RE: 908 Cagua Dr NE
Grading and Drainage Plan
Engineer's Stamp Date: 03/14/2026
Hydrology File: K18D115
Case # HYDR-2026-00100

Based upon the information provided in your submittal received 03/16/2026, the Grading and Drainage Plan **is not approved** for Grading Permit and Building Permit. The following comments need to be addressed for approval of the above referenced project.

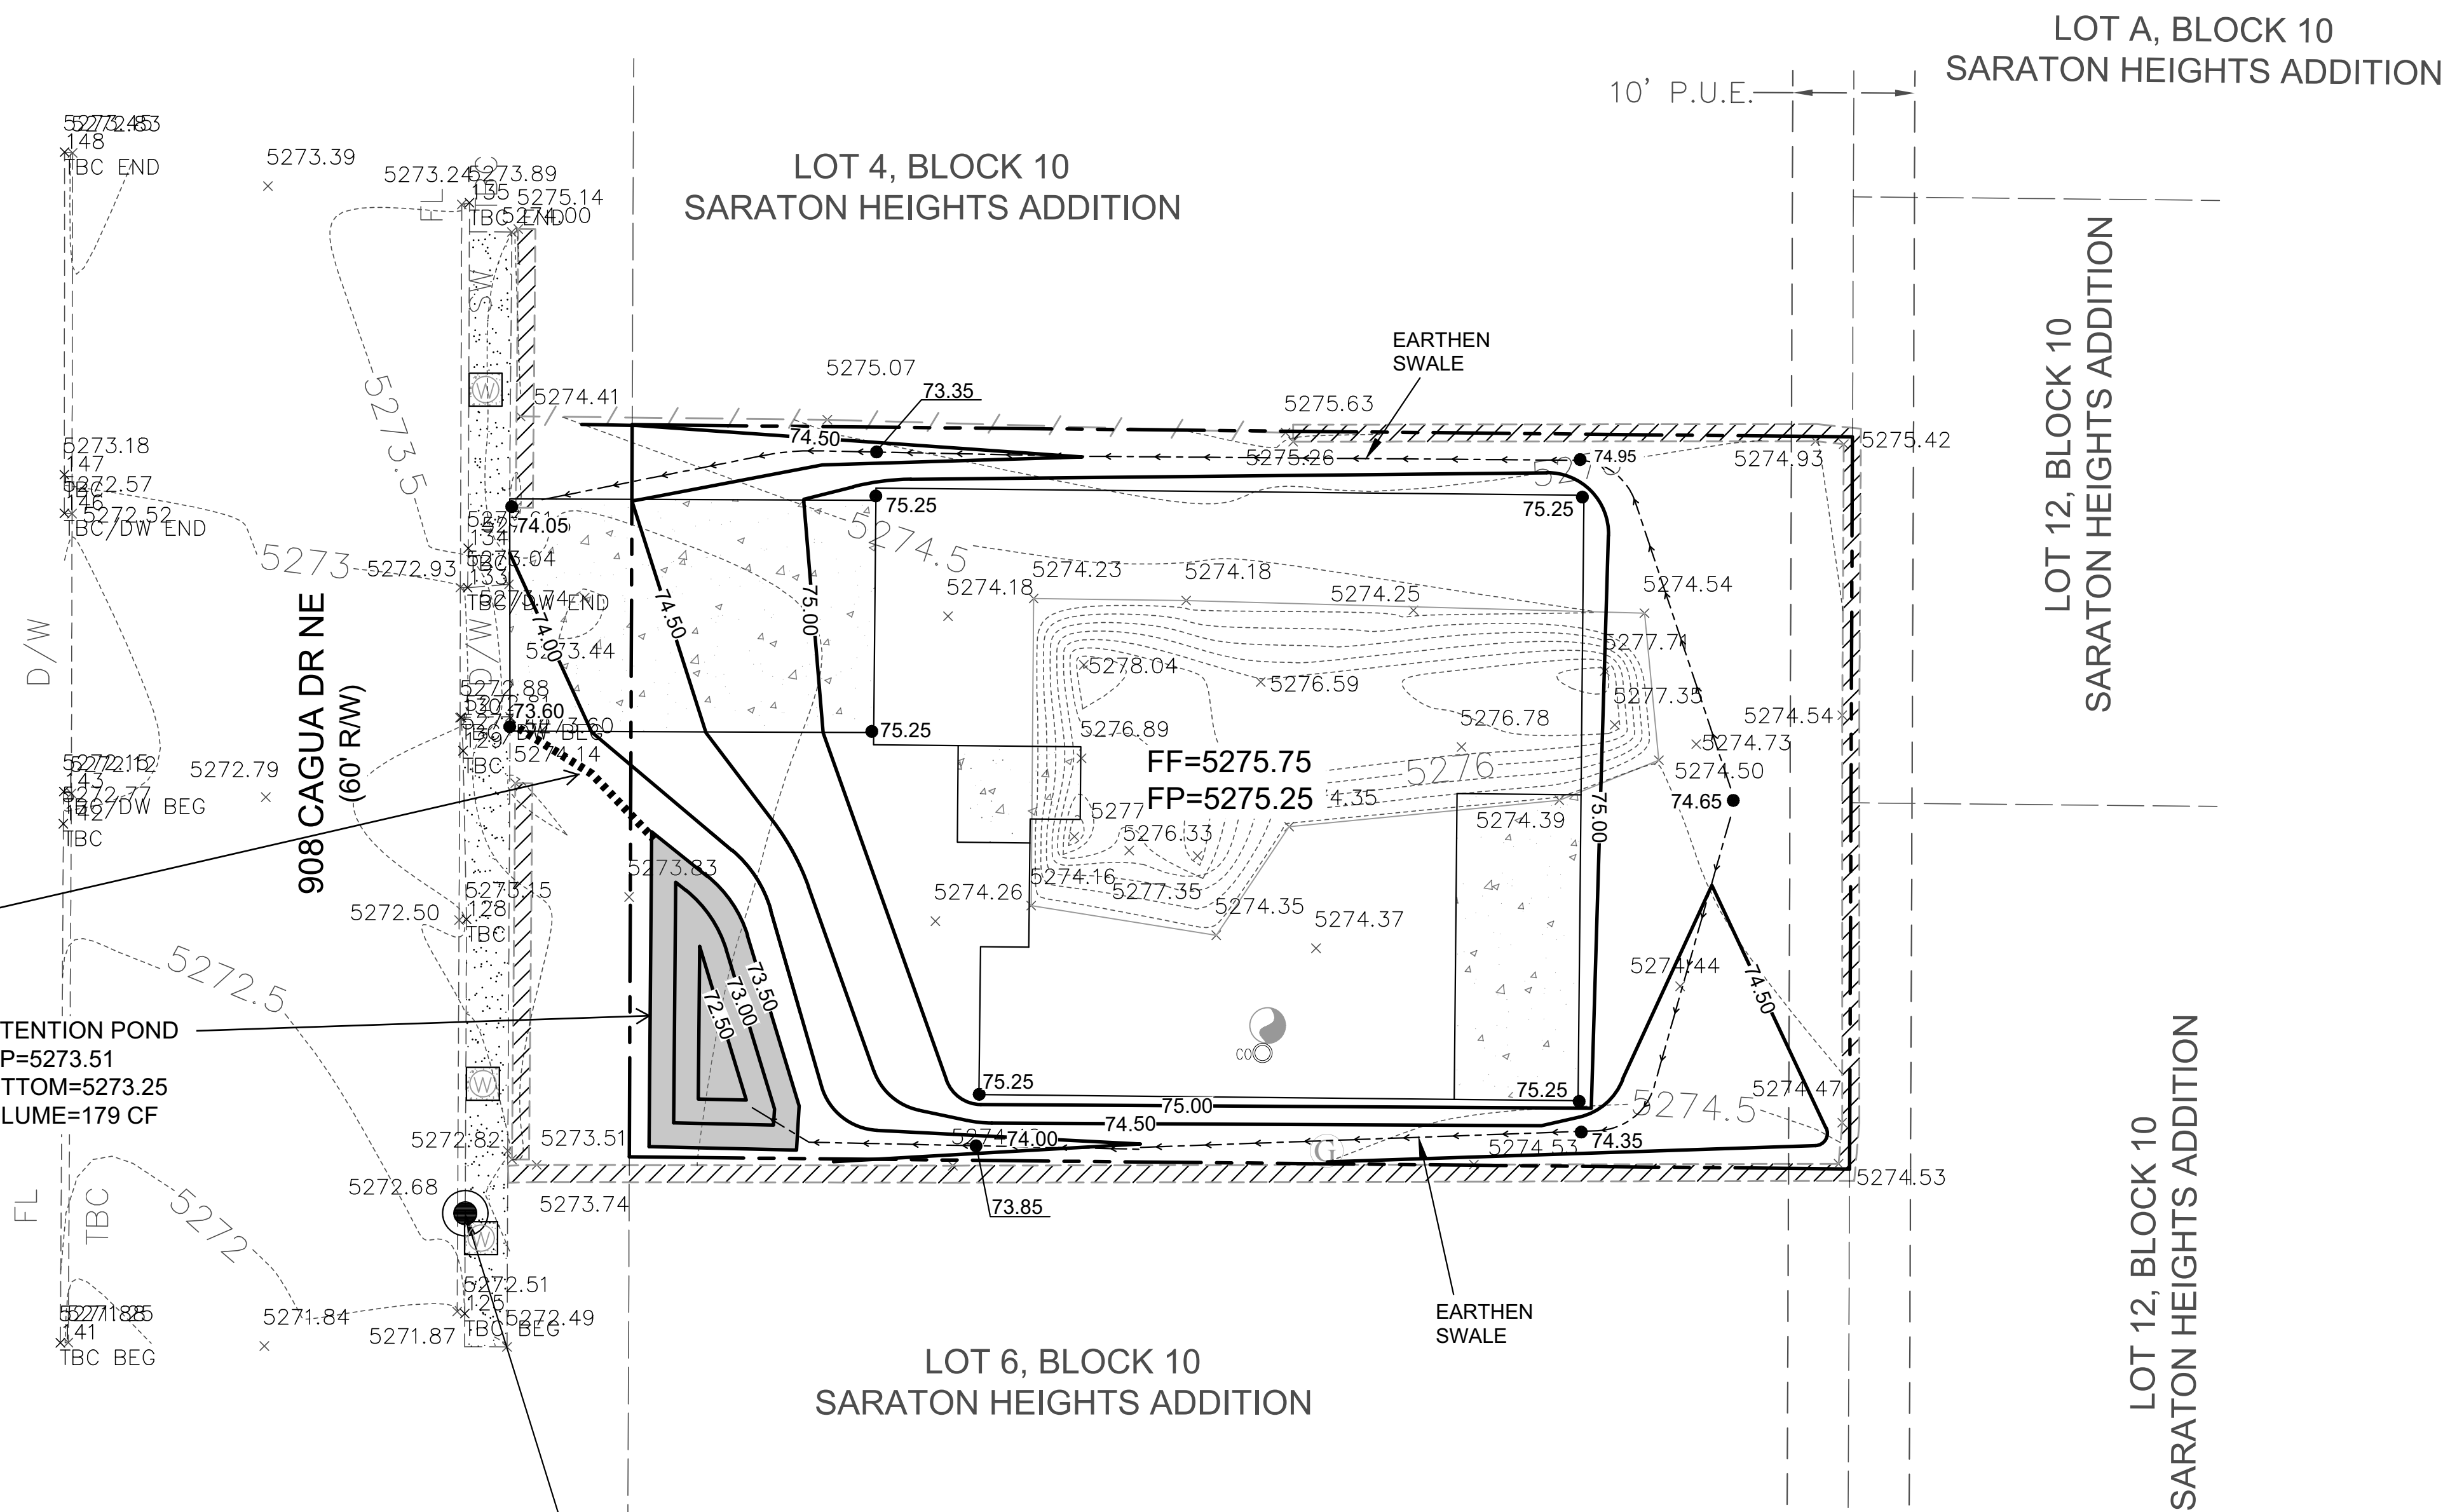
1. Please provide a vicinity map showing the location of the site. Typically, this is the Zone Atlas. This can be downloaded in pdf format from the City of Albuquerque's website.

2. Please demonstrate how water will overflow to the driveway and not cross over the sidewalk in the area circled below.
